WEST SUSSEX COUNTY COUNCIL CONSULTATION

TO:	Arun District Council - FAO: Amber Willard
FROM:	WSCC – Highways Authority
DATE:	10 August 2026
LOCATION:	Sefter Farm Pagham Road Pagham PO21 3PX
SUBJECT:	P/76/26/PL Construction of a new engineering block building and car parking areas together with a new access road, footpaths and hard standing area. This application may affect the setting of a listed building and is in CIL Zone 5 (Zero Rated) as other development. An amendment to the above application dated 24th July 2026 relating to:- Swept Path analysis, Travel Plan and response to comments.
RECOMMENDATION:	No Objection

SWEPT PATH ANALYSIS -
BUS

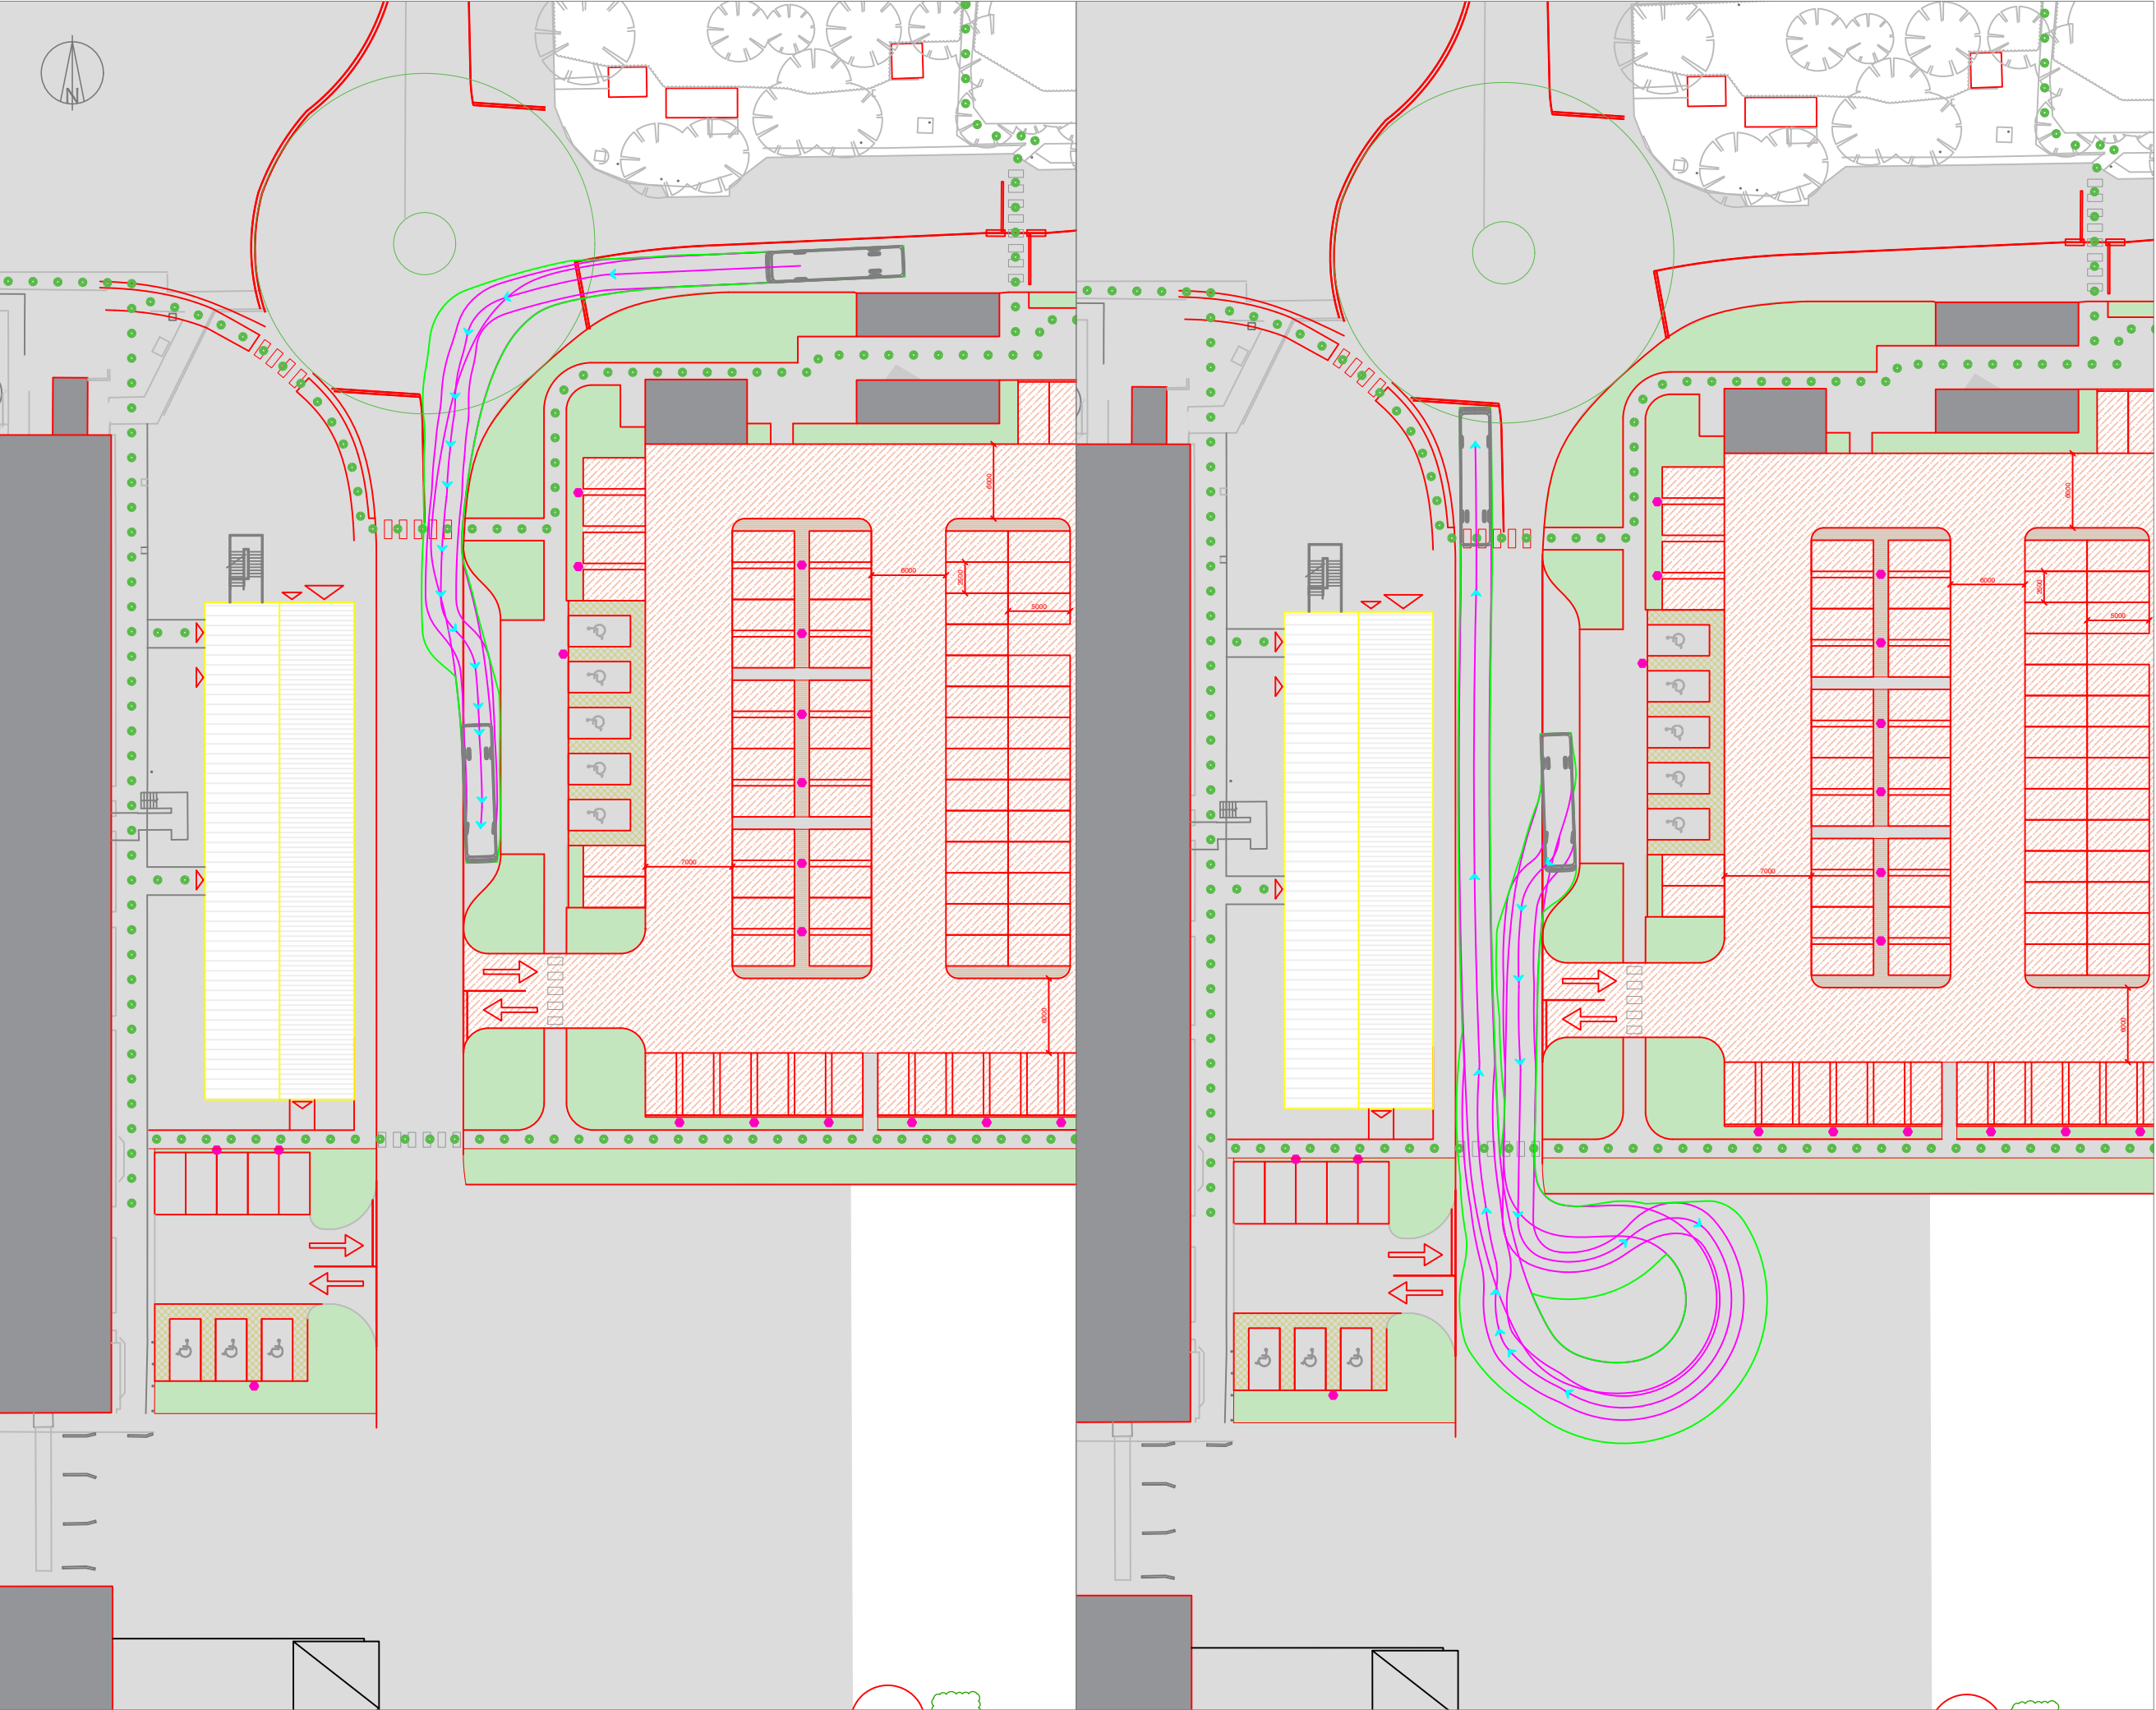
Swept path tracking for bus for new bus stop location, including turning on site.

Swept path tracking for bus at the new bus stop location has been provided, including a turn within the site so this can exit to the internal roundabout and on to public highway in a forward gear.
